Application no: **3/2021/0889**

Address: **Building K Mitton Road Business Park Mitton Road Whalley BB7 9XE**

Proposal: **Proposed change of use from B2 (General Industry) to E (E Commerical Business and Service) as well as external alterations.**

The Local Highway Authority have viewed the plans and highway related documents and have the following comments to make:

Drawing Title
Proposed Site Plan

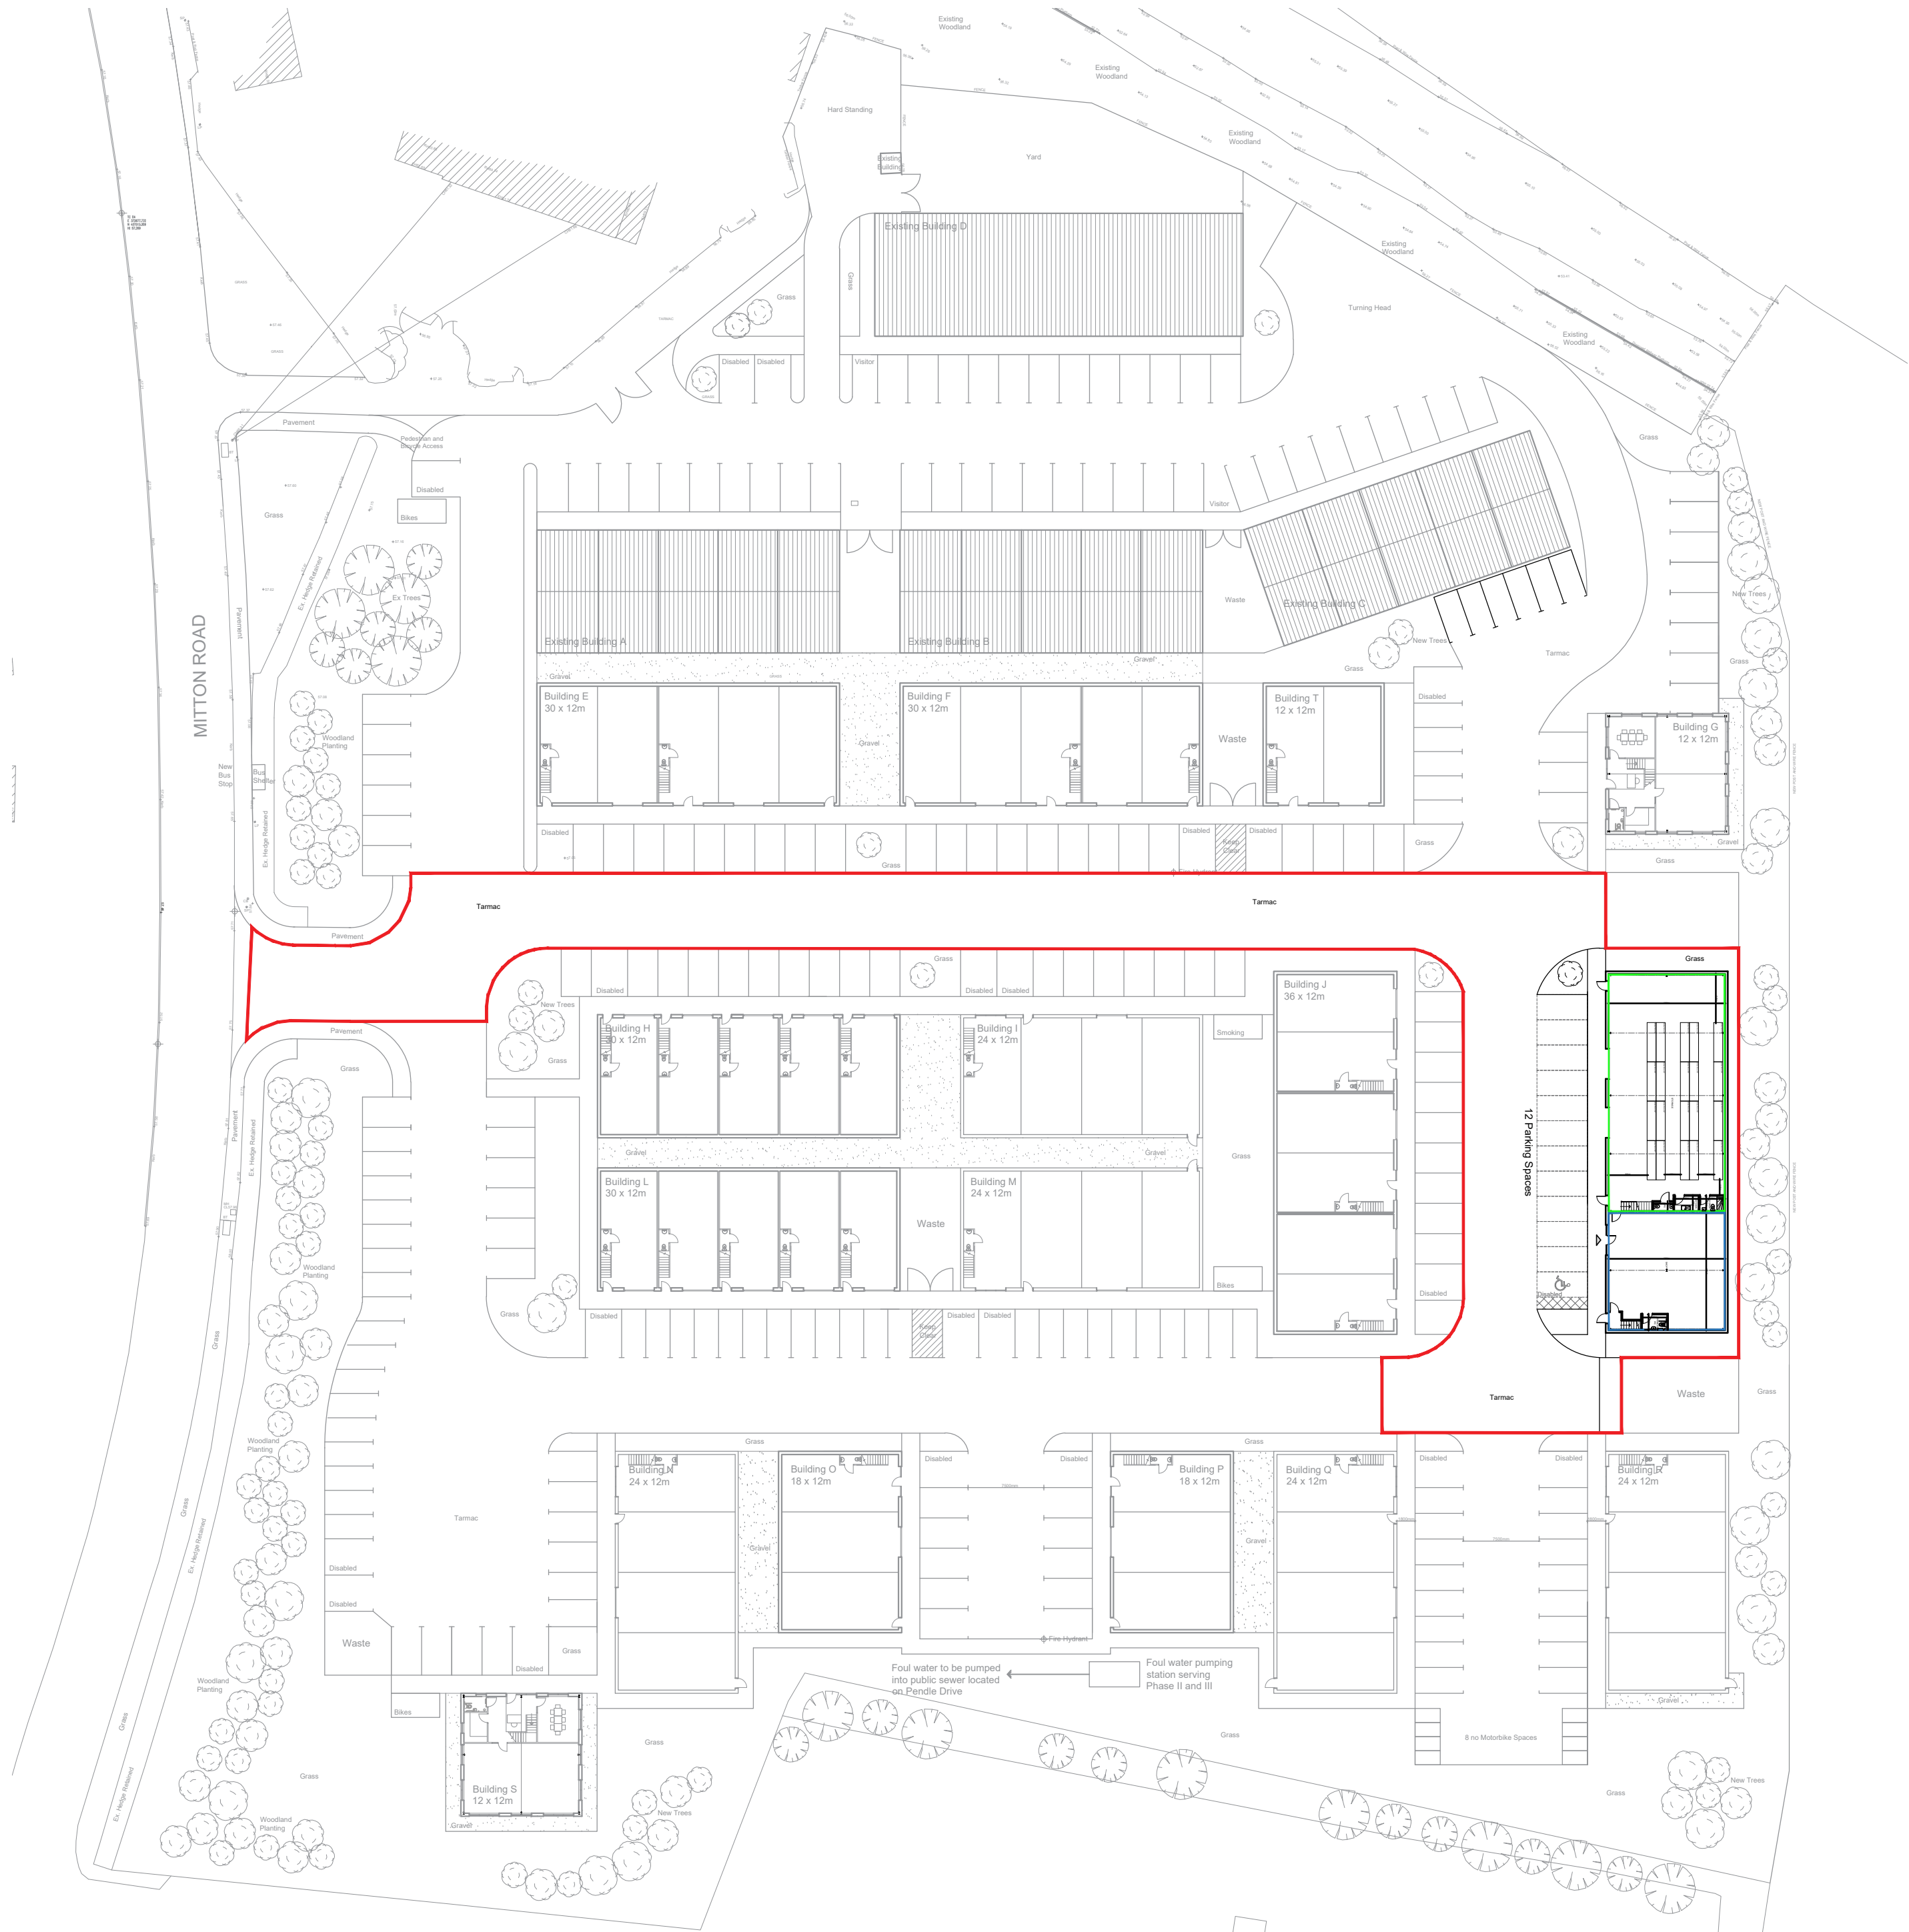
The LHA have reviewed SPA drawing number 6429-P02 titled "Proposed Site Plan" and understands the site will provide 11 car parking spaces.

For the development to comply with the Joint Lancashire Structure Plan, the LHA require the Unit to provide 12 car parking spaces as per the internal floor area of the mixed-use development. Therefore, there is a shortfall in one car parking space.

Notwithstanding this, the LHA will accept the shortfall in parking with there being ample car parking spaces around the Business Park and there being 6 designated car parking spaces for the 6 full time employees. Therefore, the LHA will accept the shortfall.

1. The development hereby permitted shall not be occupied until such time as the parking and turning facilities have been implemented in accordance with SPA drawing number 6429-P02. Thereafter the onsite parking provision shall be so maintained in perpetuity.
